KIRKLEES METROPOLITAN COUNCIL INVESTMENT & REGENERATION SERVICE

DELEGATED DECISION TO DETERMINE APPLICATIONS FOR CONSENT, AGREEMENT OR APPROVAL REQUIRED BY CONDITION

Reference No:	2022/44/91598/W
Site Address:	former, Stile Common Infant & Nursery School, Plane Street, Newsome, Huddersfield, HD4 6DF
Description:	Discharge of conditions 3 (Construction Management Plan), 4 (Construction Environmental Management Plan), 5 (road condition survey), 6 (Remediation Strategy), 9 (coal legacy) , 11 (estate roads), 12 (drainage under highway), 13 (highway retention), 14 (arboricultural method statement), 15 (Ecological Design Strategy), 16 (drainage scheme) and 17 (temporary drainage) of previous permission 2020/92067 for erection of 30 dwellings
Recommending Officer:	Nick Hirst

DECISION - Discharge of Conditions – Split Decision

TYPICAL MANHOLE DETAIL-TYPE A

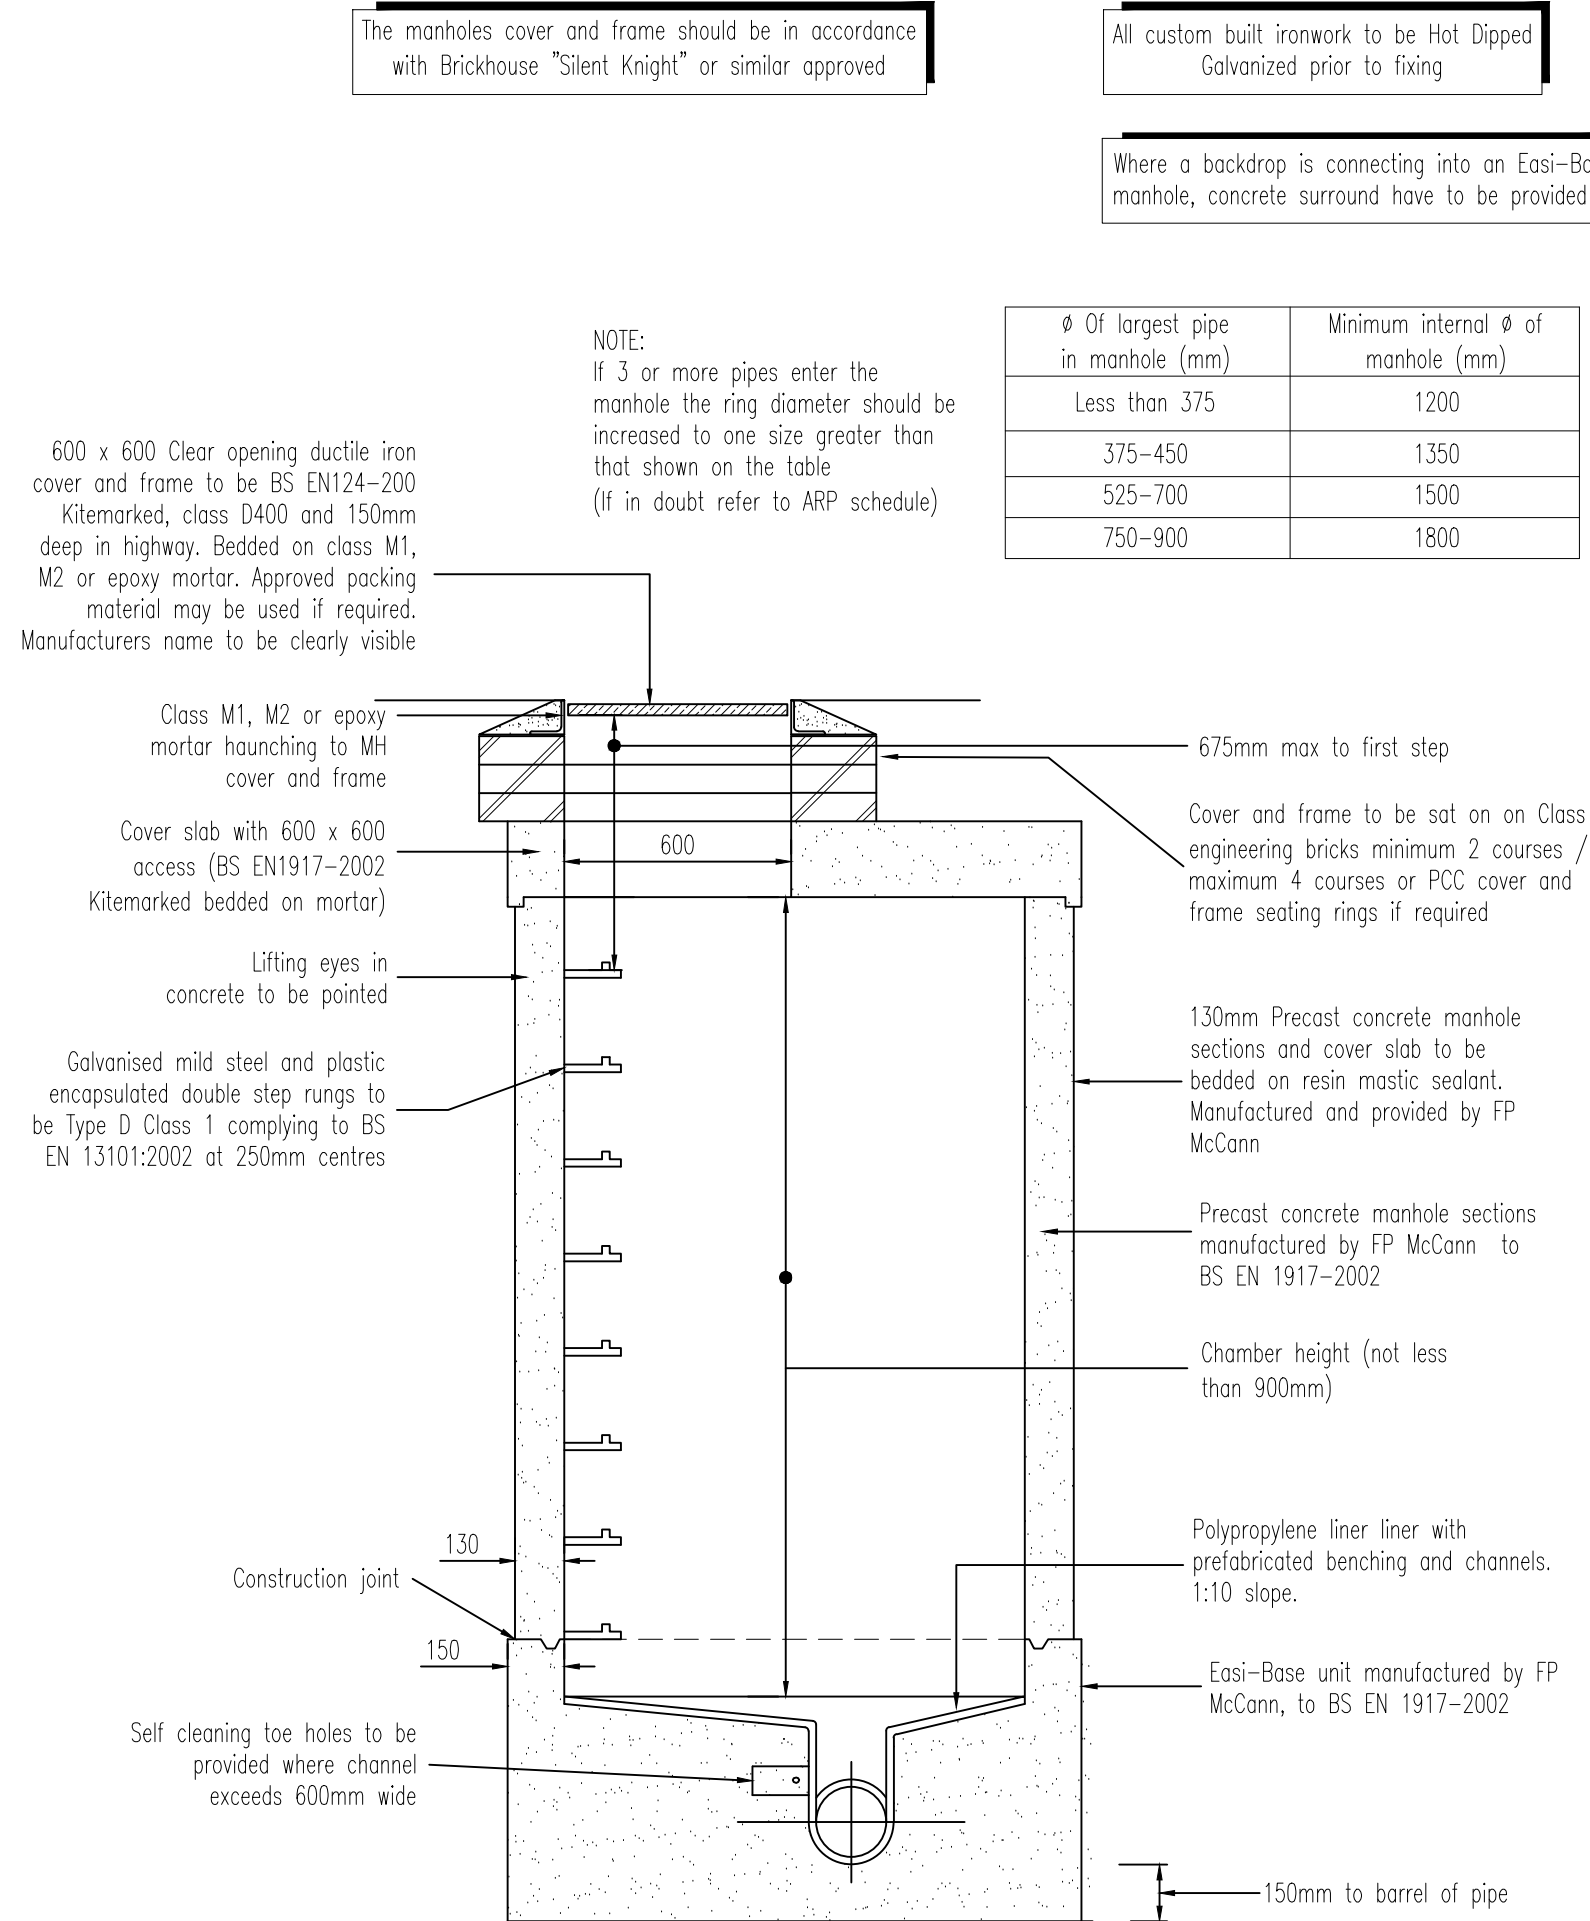
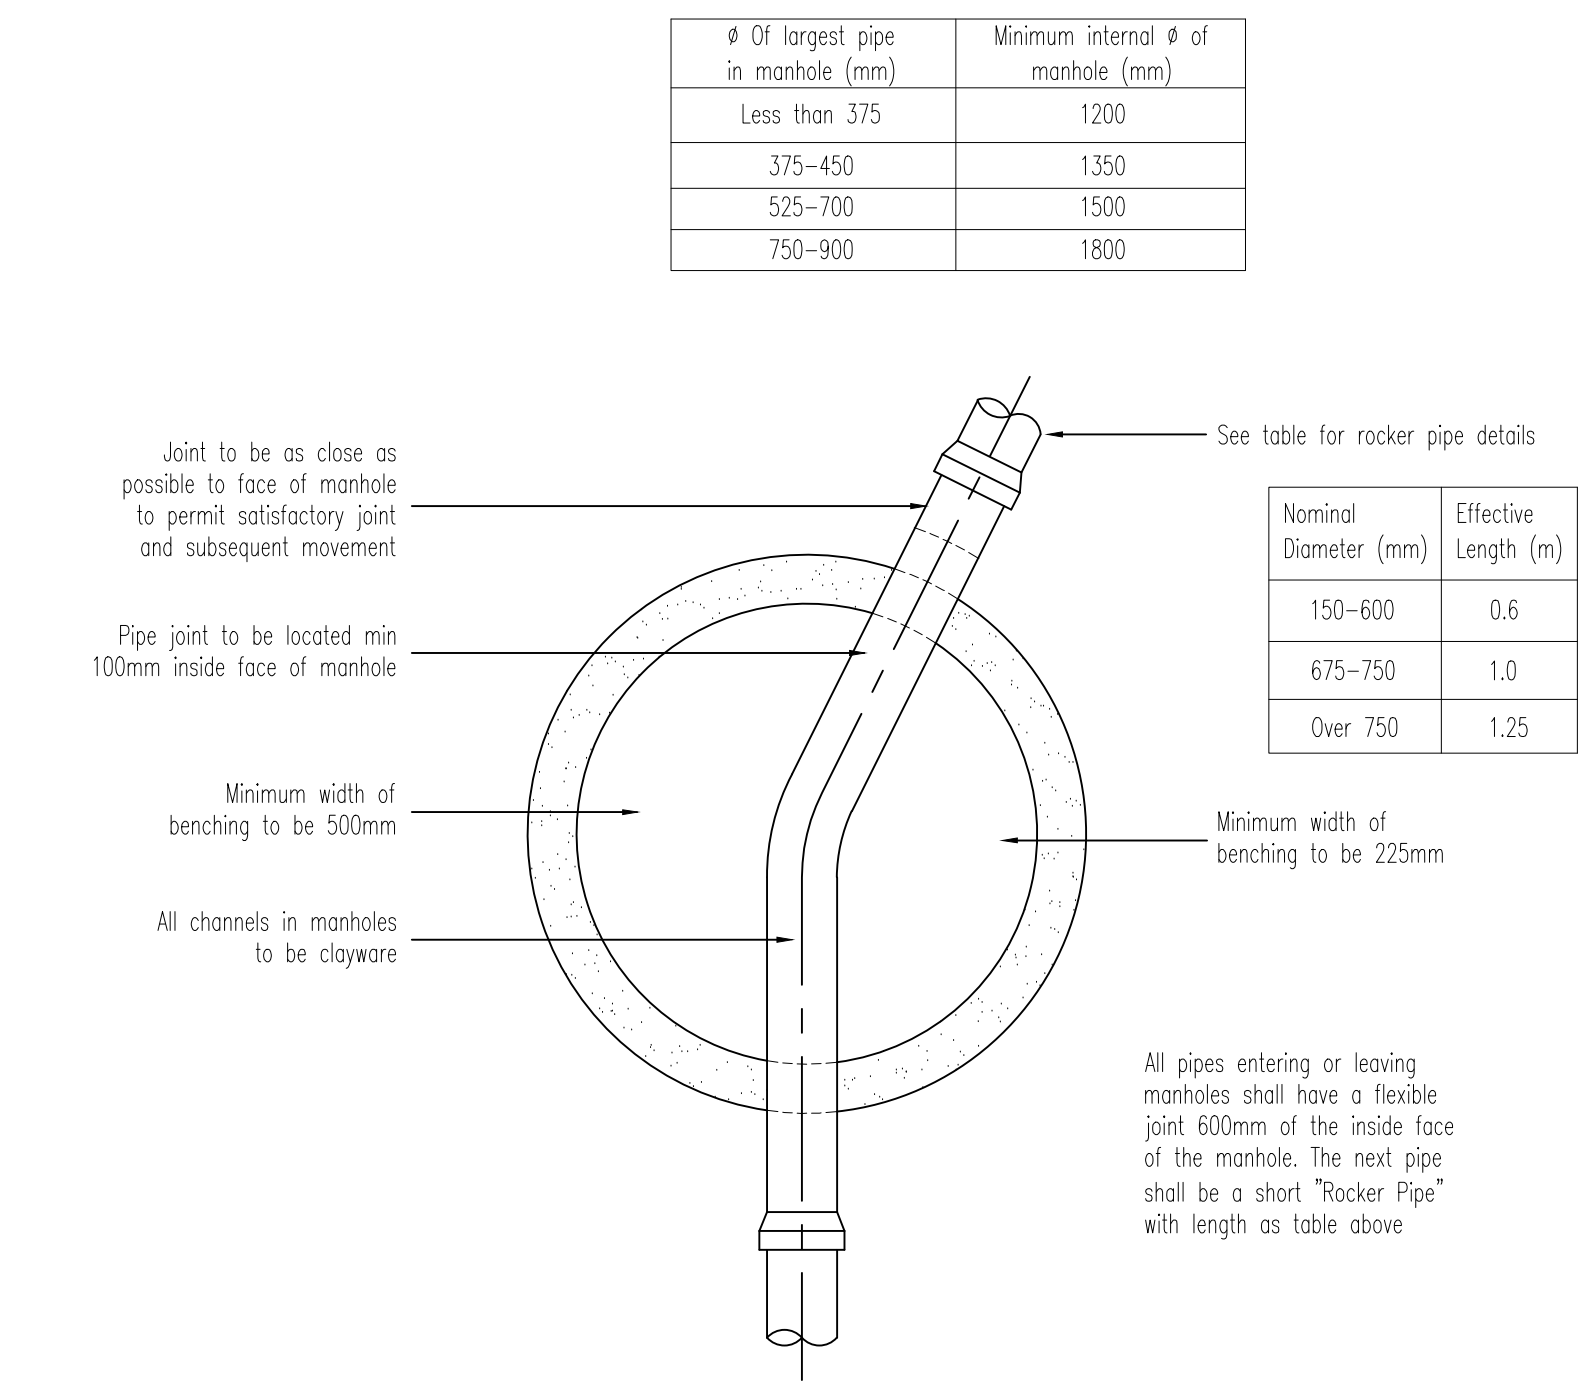
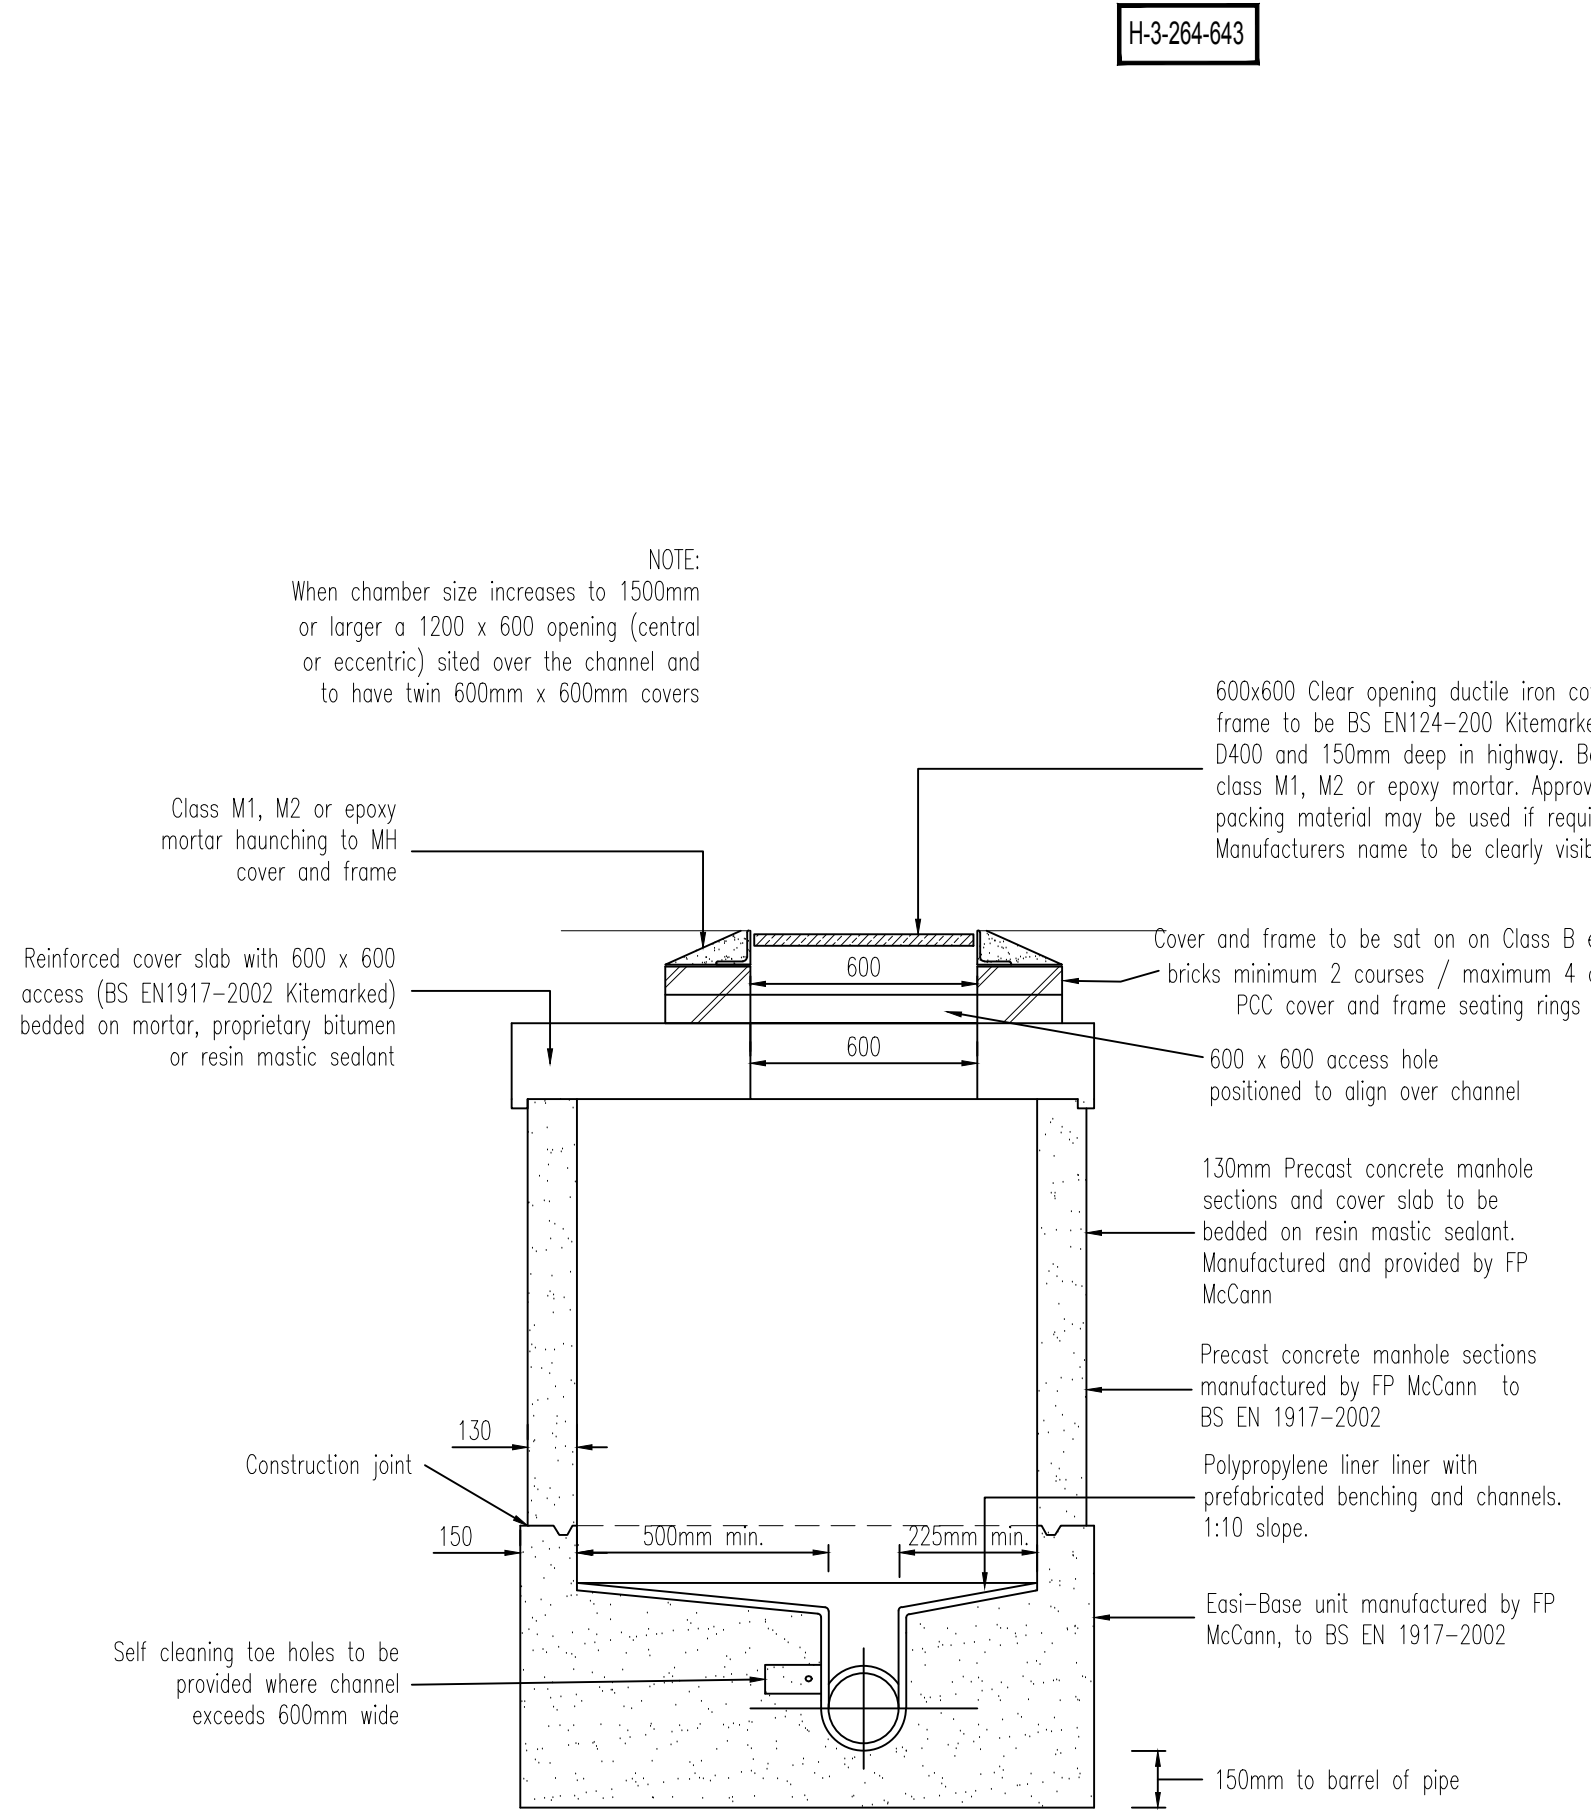
The submitted information is considered insufficient to discharge condition 16. Further information regarding the proposed surface water drainage scheme, including a condition survey of the surface water drain in Plane Street (via MH C1 on drawing 0257/05/03), is required, to demonstrate it is a suitable connection point. A CCTV survey of the existing drain should be supplied to indicate the condition of the pipework.
